TR010034 DEADLINE 9 - CPRE PDSY REBUTTAL OF REP8-018 - NH'S POST-HEARING RESPONSE TO ISH3 QUESTIONS

REFERENCE NUMBER	ISH 3 QUESTIONS AND NH RESPONSE TO THEM [REP8-019]	CPRE RESPONSE TO NH REP 8-019
Item 2 Transport Networks and Traffic		
9.75.4	No traffic data collected during the Covid-19 pandemic has been used in the traffic modelling for the Scheme	If this is the case then why does the Case for the Scheme and ES Ch.6 Air Quality refer to data collected and used in the traffic modelling (summarised in REP8-045)? NH says observed flows are used to calibrate and validate the model ie they are used in the traffic model – If data collected during the Covid pandemic was used to check the calibration and validation of the model we still don't know the implications of this.

Drawing Title  
FIGURE 7.2  
LOCAL LANDSCAPE CHARACTER

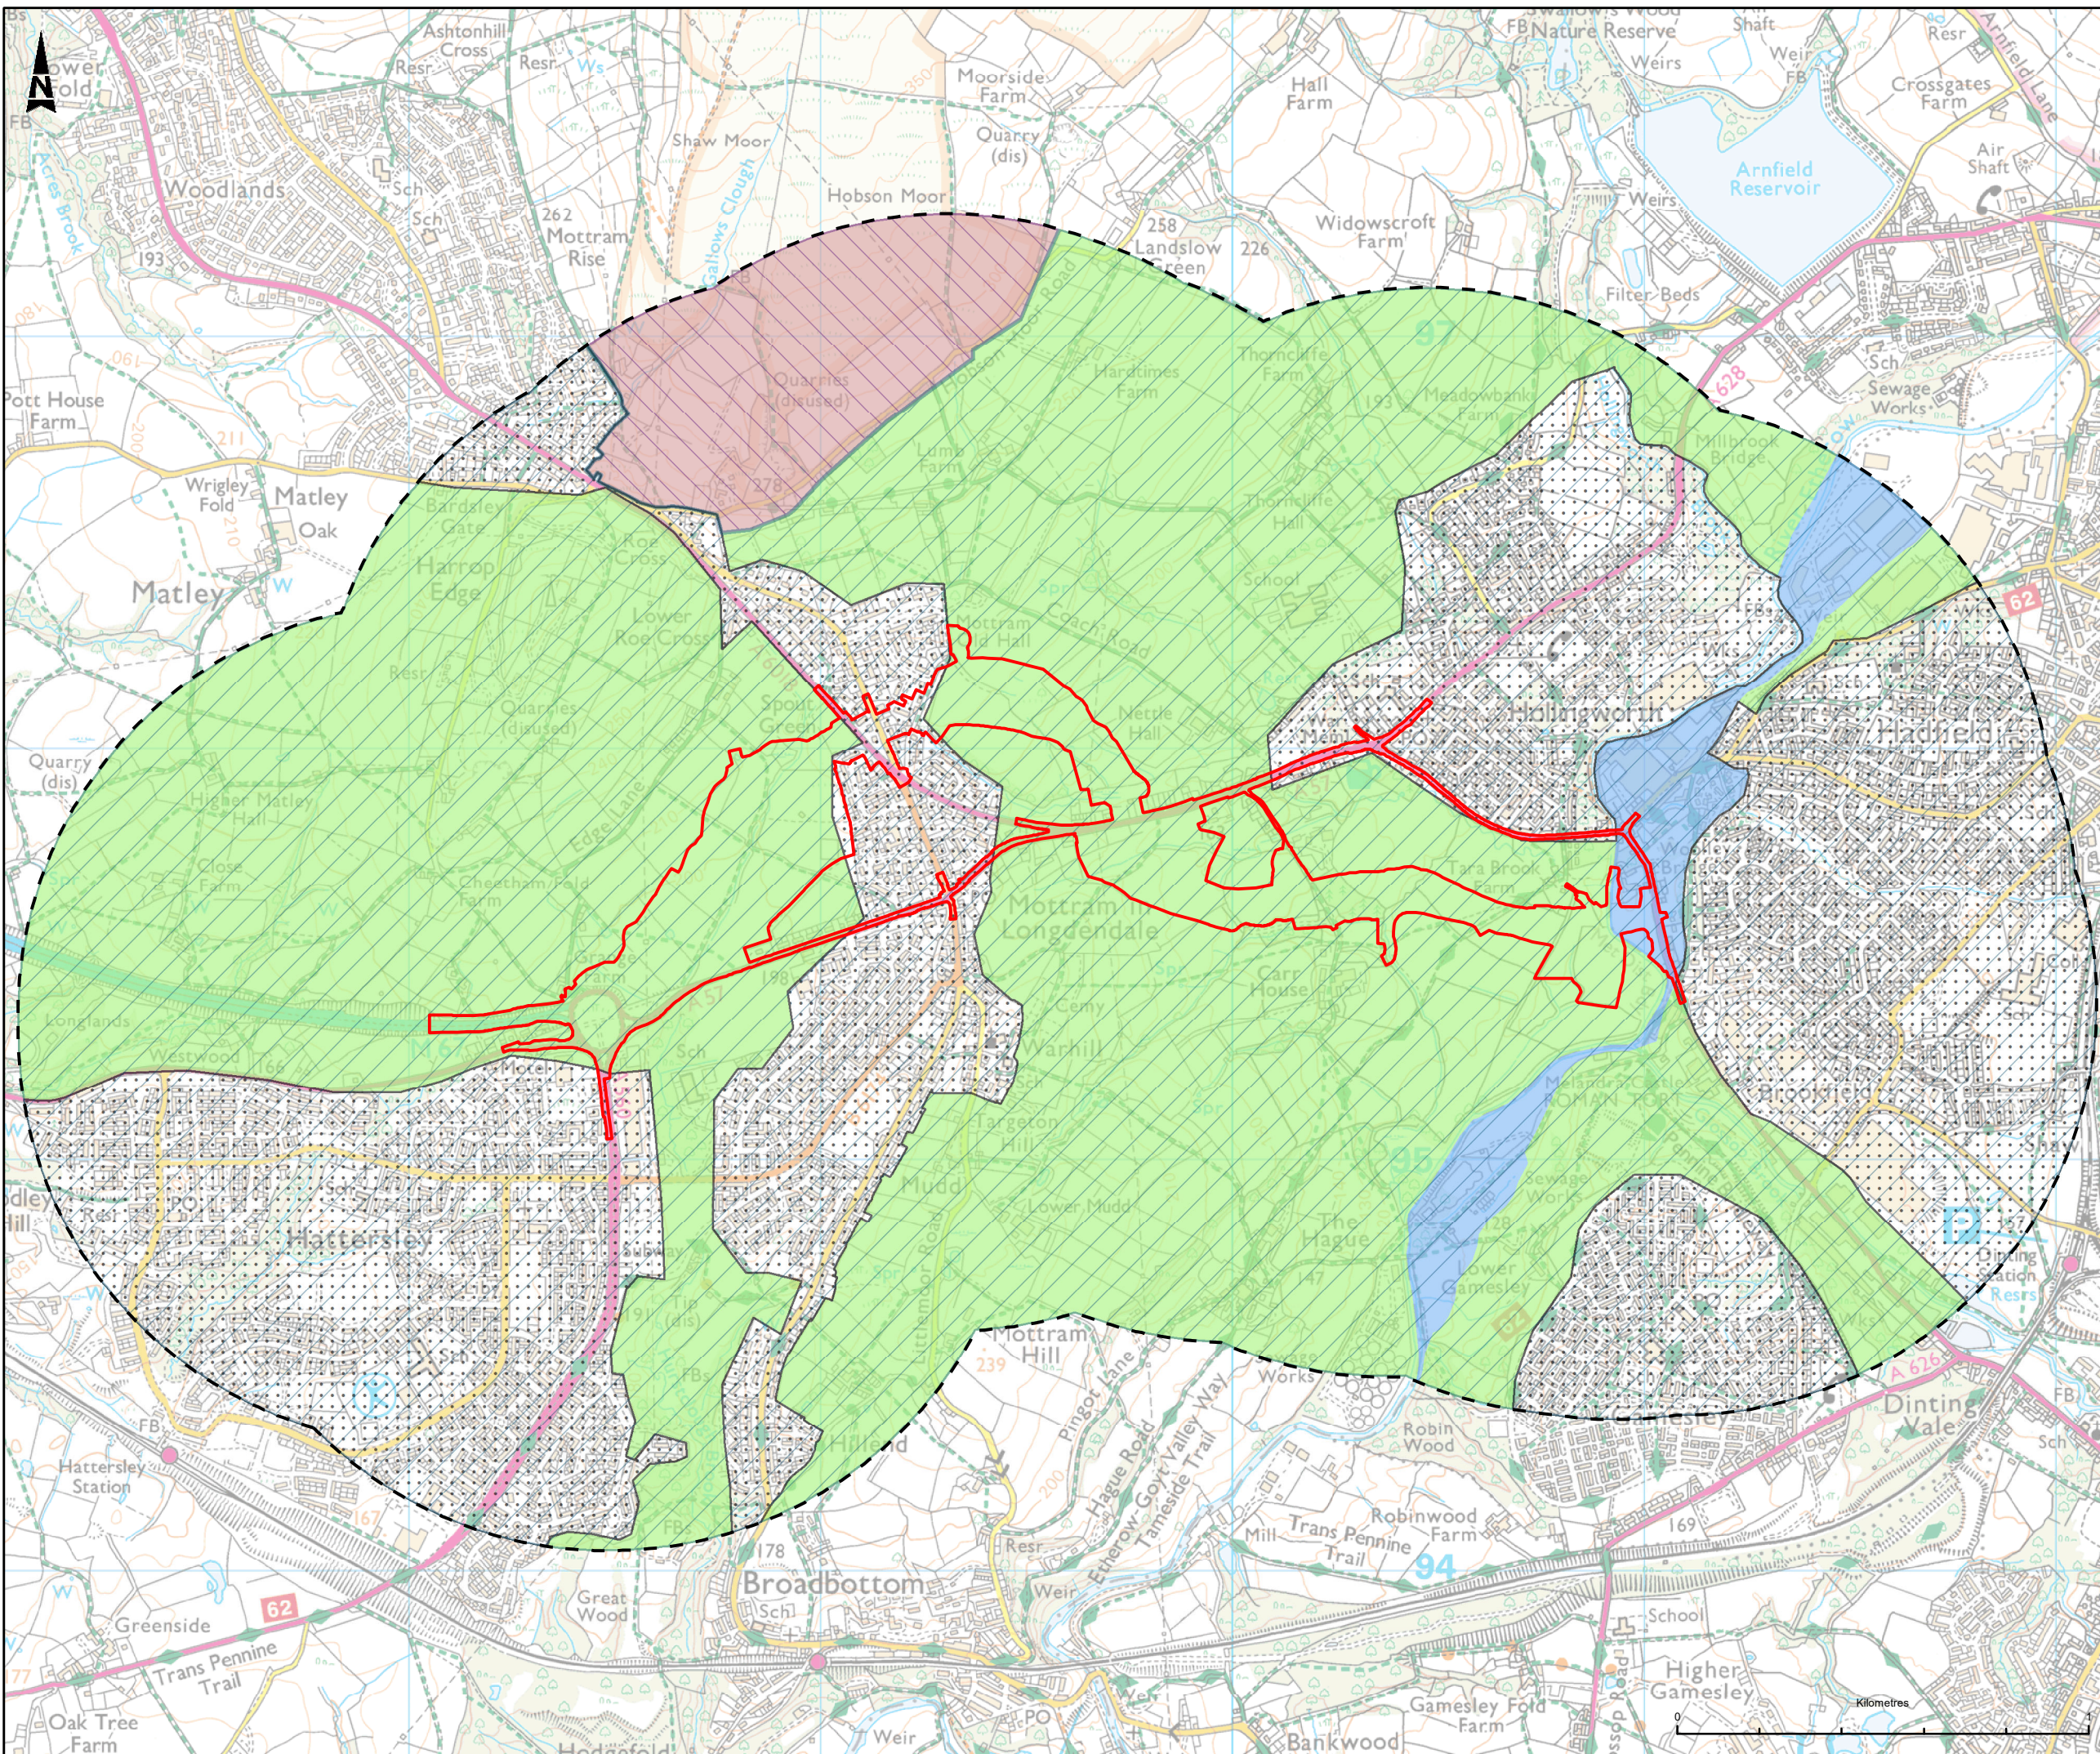
9.75.43	Great weight has been applied through the assessment of LVIA	We do not agree that the magnitude of impacts from the increased traffic on both trans-Pennine roads is negligible – it is minor. For both landscape and visual sensitivity minor change on receptors of high sensitivity leads to a magnitude moderate/large significance [REP6-006 ES Ch.7 Tables 7.14 & 7.19]. A moderate significance is a material consideration.
